RE: 6/2017/2910/COND - Plot 4100, Gypsy Moth Avenue, Hatfield BuisnessPark, Hatfield - Submission of details pursuant to condition 8 (Archaeological Written Scheme of Investigation) on planning permission 6/2015/2043/OUTLINE, dated 05/10/2015

The submitted archaeological Written Scheme of Investigation (WSI) does not yet meet the requirements of this office. **So we cannot yet recommend that the archaeological condition be discharged or partially discharged.**

**Hatfield Motor Dealership Site,
Gypsy Moth Lane, Hatfield, Hertfordshire**
Proposal for Archaeological Evaluation
Figure 1. Location of trenches

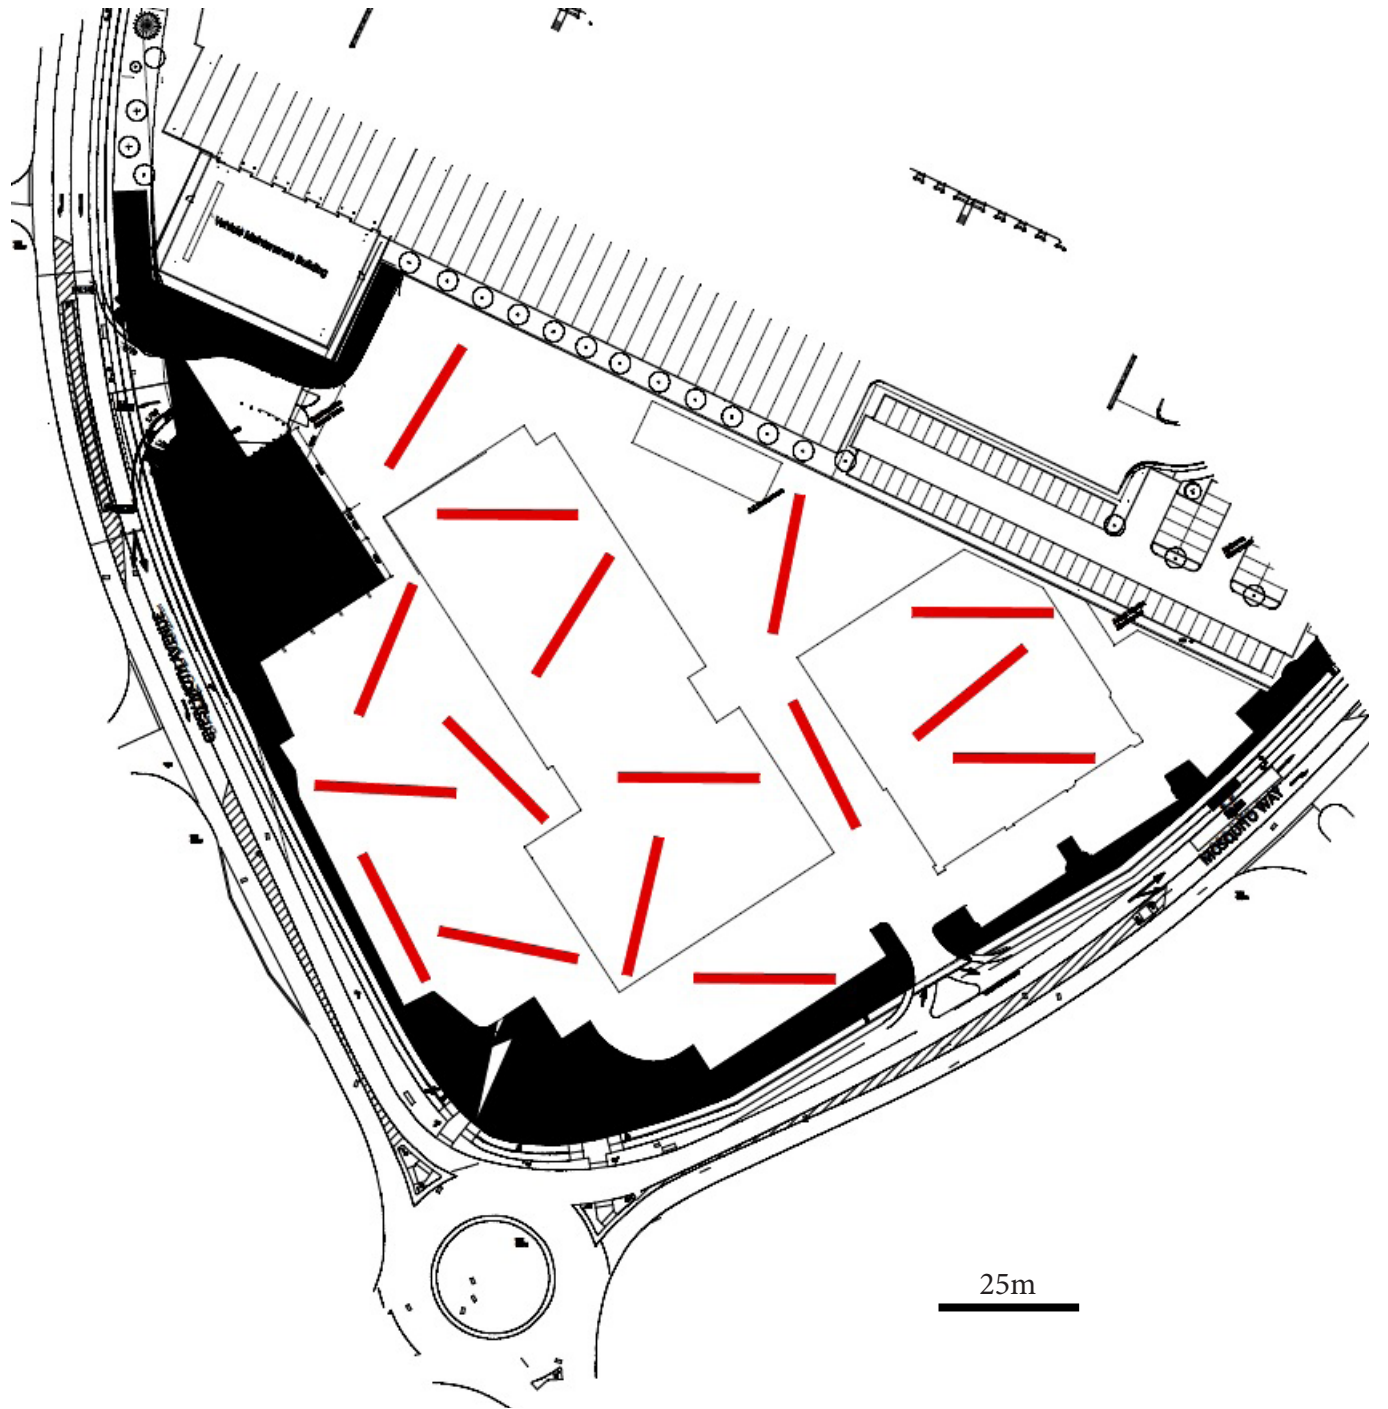
- paragraph 2.2 should note that further method statements will be submitted should further phases of archaeological works be necessary
- paragraph 4.2 and 5.10 should demonstrate that the archaeological contractor has visited the site and contacted the applicant for information pertinent to the formation of the trench plan, this will include the location of services, trees, ditches and any other potential obstructions, and that these have been taken into account when drawing up the trench plan
- paragraphs 9.2 and 9.3 should note the correct museum and show that they have agreed to take any archive
- details of the experience and numbers of onsite archaeological staff should be provided
